FALCON ACRES EL PASO COUNTY CONSTRUCTION DRAWINGS JANUARY 2023

PCD FILING NO.: SF223

CONSTRUCTION PLANS
COVER SHEET

NO.	DESCRIPTION	DATE										721 S. 23RD ST COLORADO SPRINGS, CO 80904 OFFICE: 719-635-6422 FAX: 719-635-6426 www.tnresinc.com 		PROJECT: MOONGLOW HEIGHTS FROM: 10+00.00 TO: 17+47.40 SUBDIVISION: FALCON ACRES DRAINAGE BASIN: _____ JOB NO.: 2142.00 SHEET: 4 OF 12	
NO.	DESCRIPTION	DATE

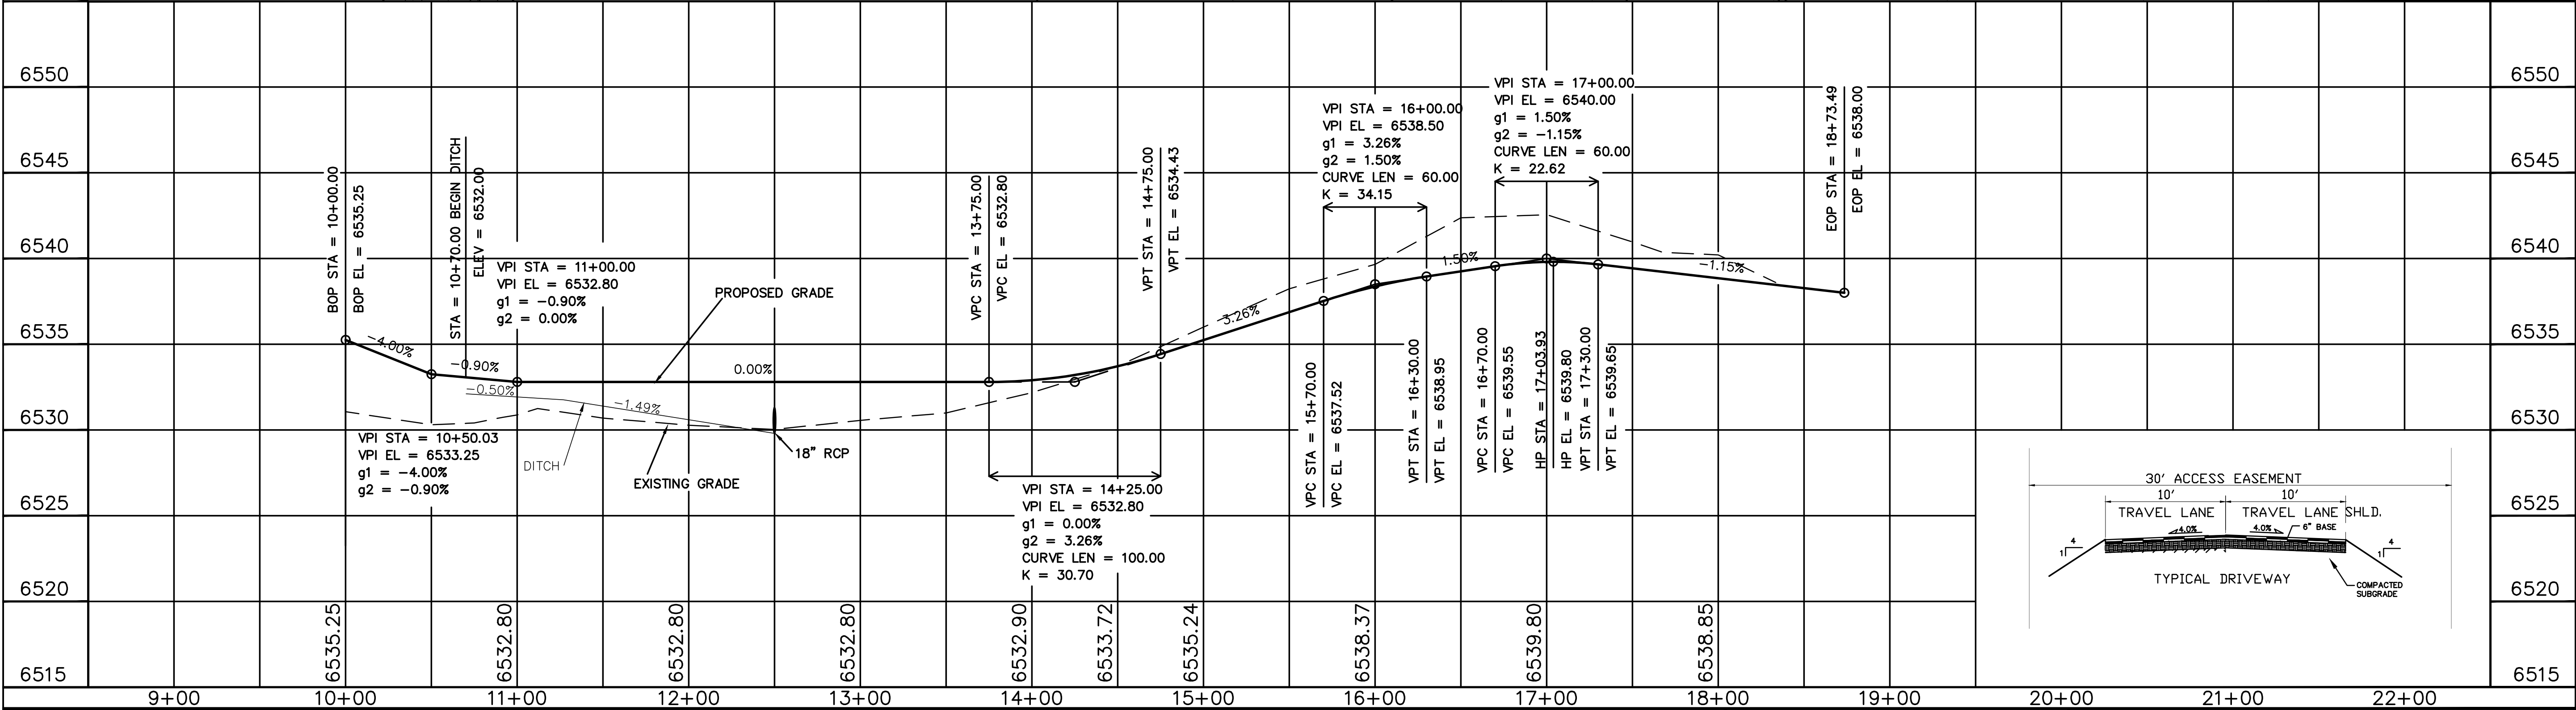
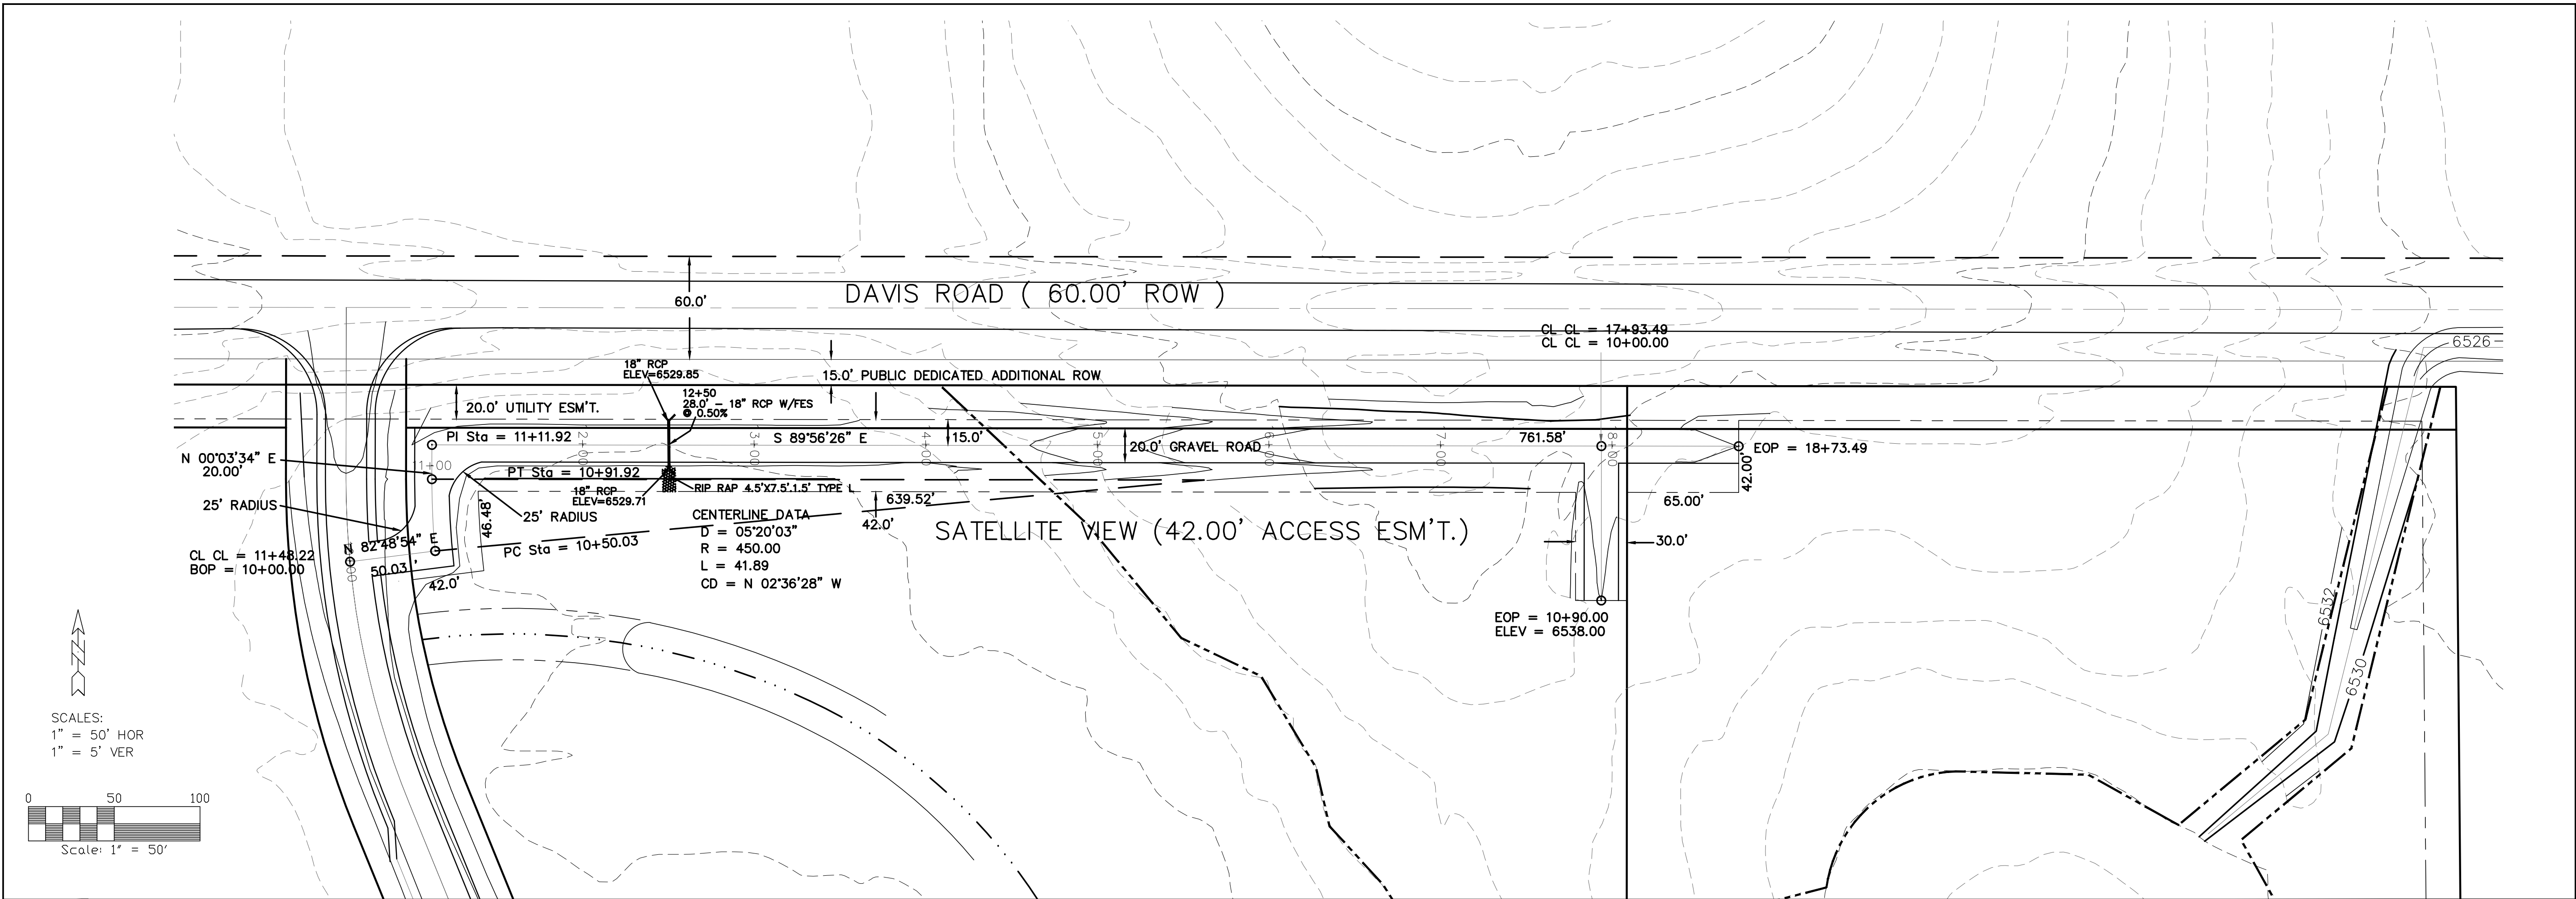
This paragraph contradicts the other engineering documents which shows 100-yr W.S. of 6533 with 53.9 ft. Update the text or the maps so they are consistent.

Provide an explanation for how/why the 24-hour 100-year vs. overflow from pond A was established at the design elevation of 6532.5. Provide an explanation for how/why the available retention storage volume up to the 6522.0 contour level within basin A is 25-28 acre.

Depending on which elevation is correct per redline comment in pg 8 of the FDR the road elevation for the private road may need to be adjusted to meet the cross flow for a local road per DCM Table 6-1. It notes depth of flow shall not exceed 6 inches at the edge of the roadway shoulder.

NO.	DESCRIPTION	DATE										721 S. 23RD ST COLORADO SPRINGS, CO 80904 OFFICE: 719-635-6422 FAX: 719-635-6426 www.tneshc.com		PROJECT: SATELLITE VIEW FROM: 10+00 TO: 18+35.92 SUBDIVISION: FALCON ACRES DRAINAGE BASIN: _____ JOB NO.: 2142.00 SHEET: 5 OF 12	
NO.	DESCRIPTION	DATE

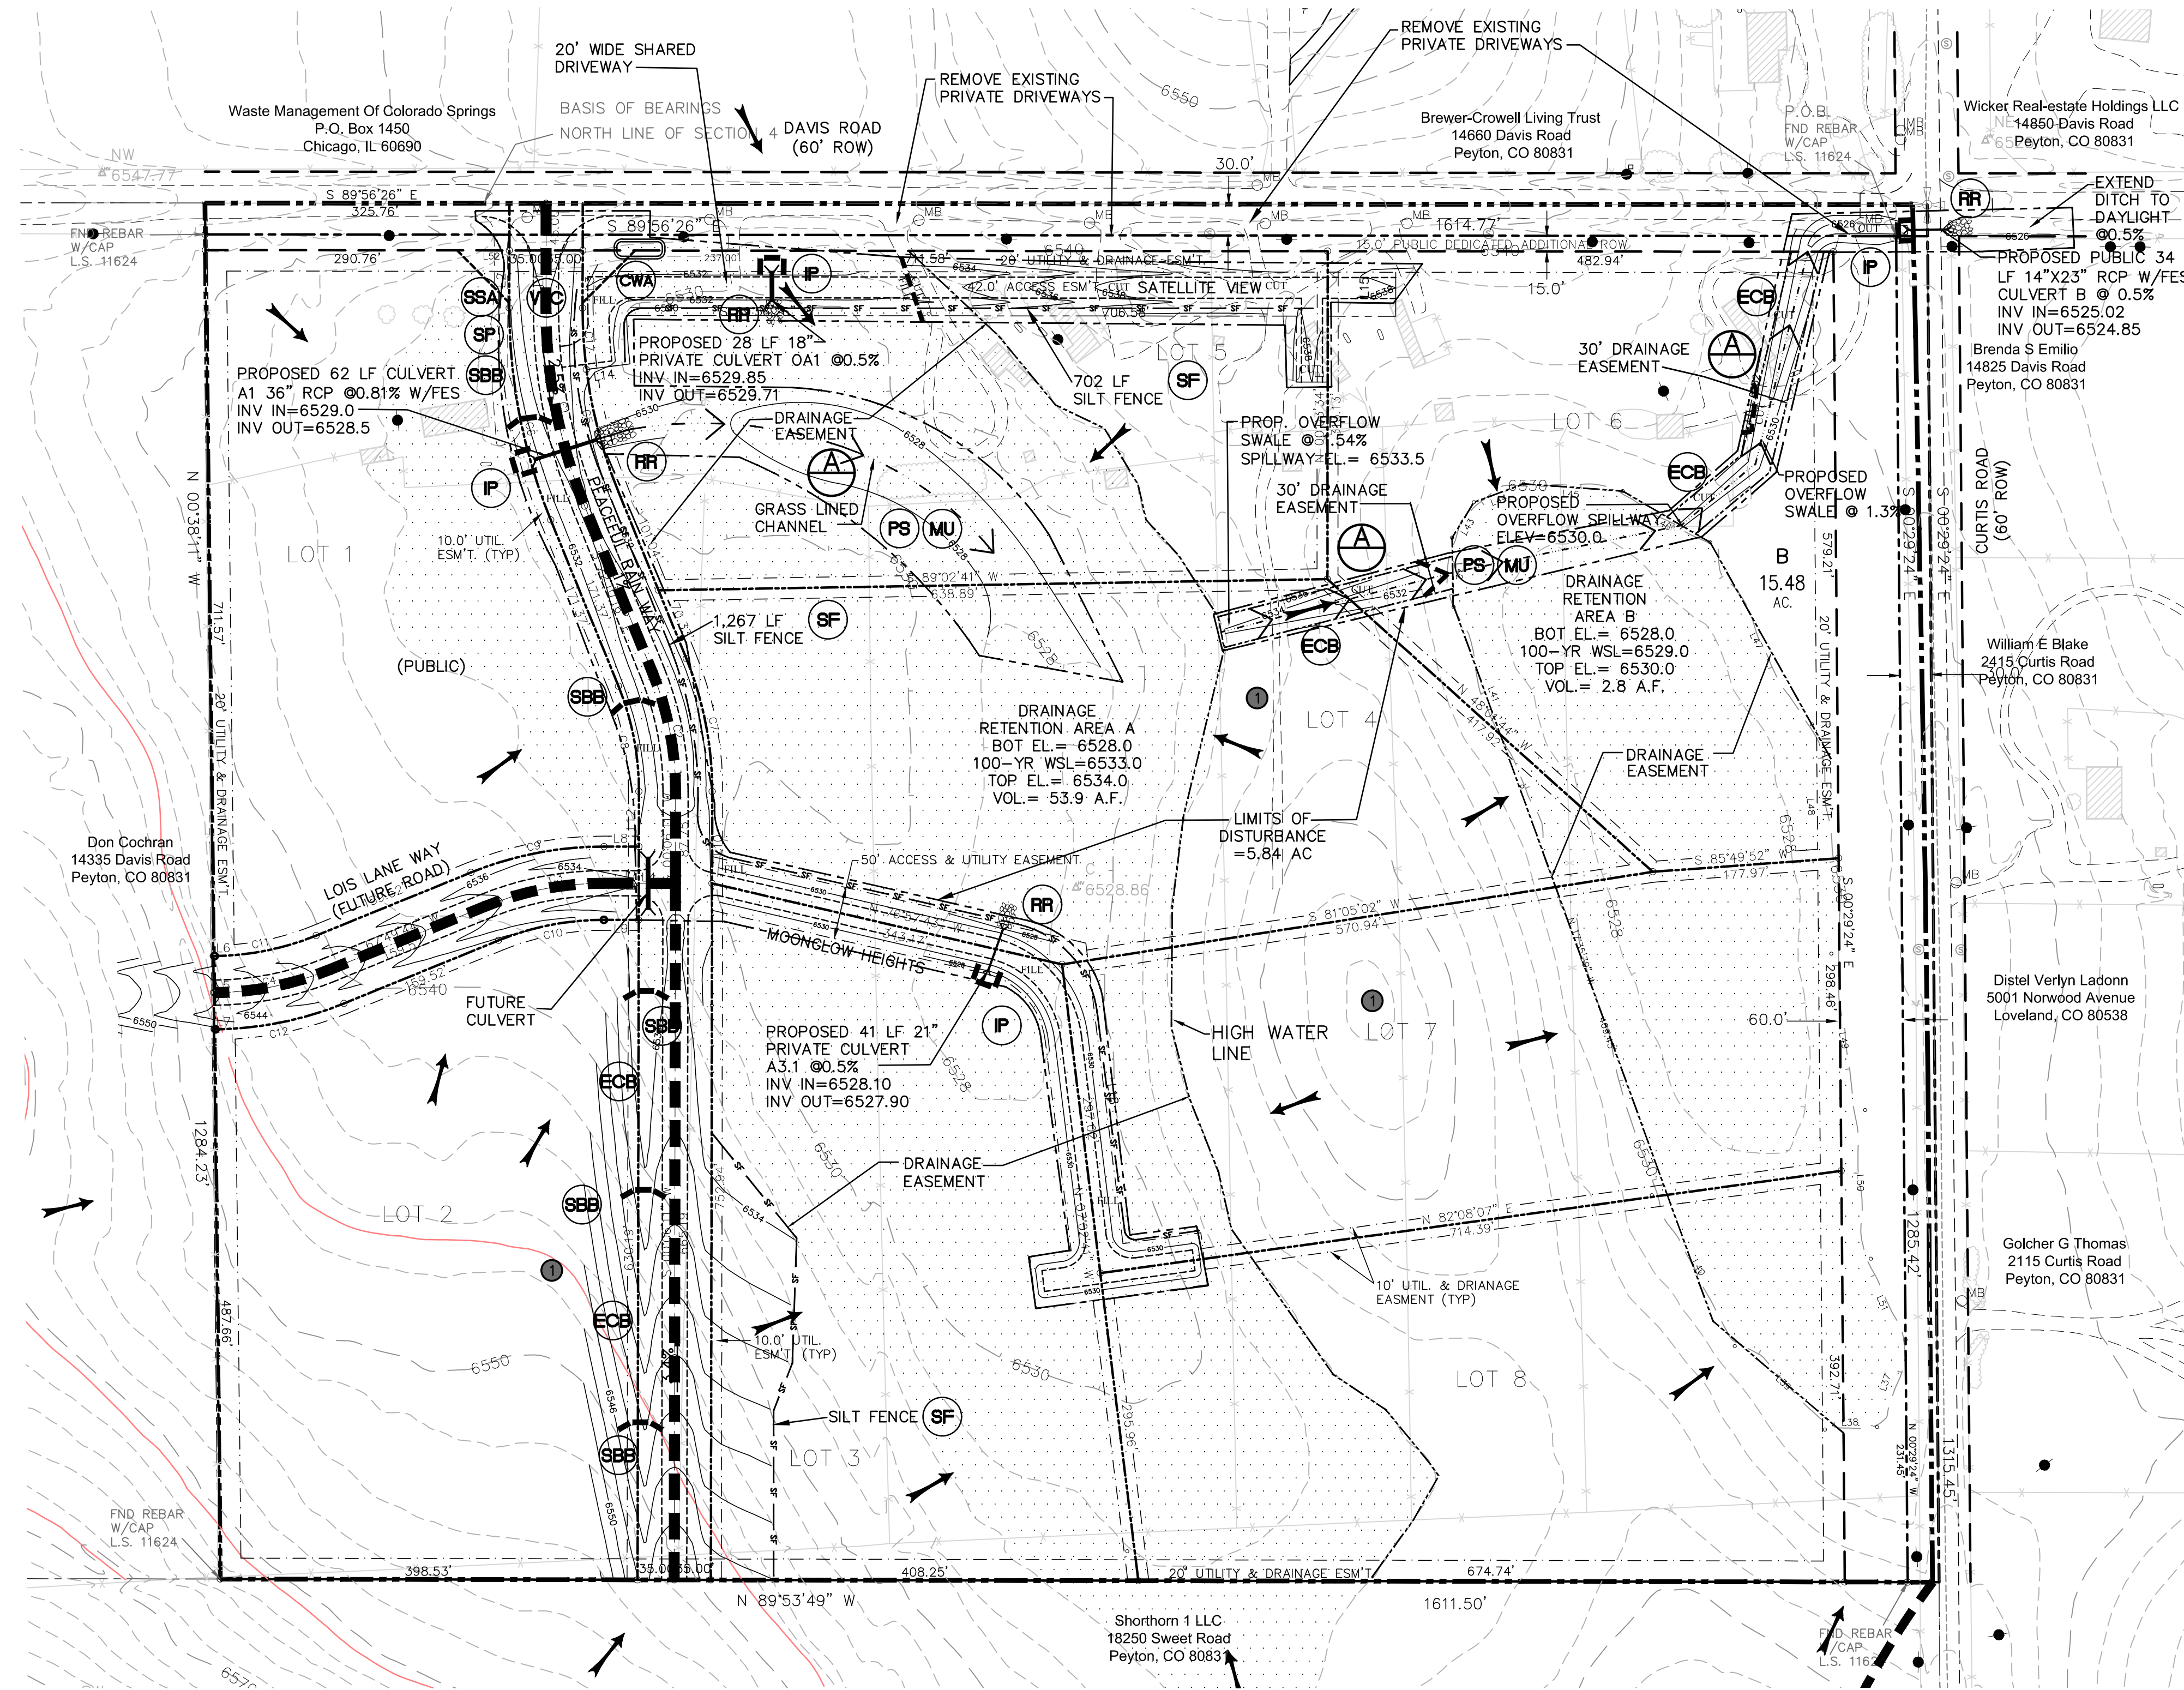
This driveway is identified with a street name on both the plat and these construction drawings. Check with enumerations if the private street "Satellite View" will be assigned to this access. If so a private street name sign should be installed. Update the FAE for the additional signage.
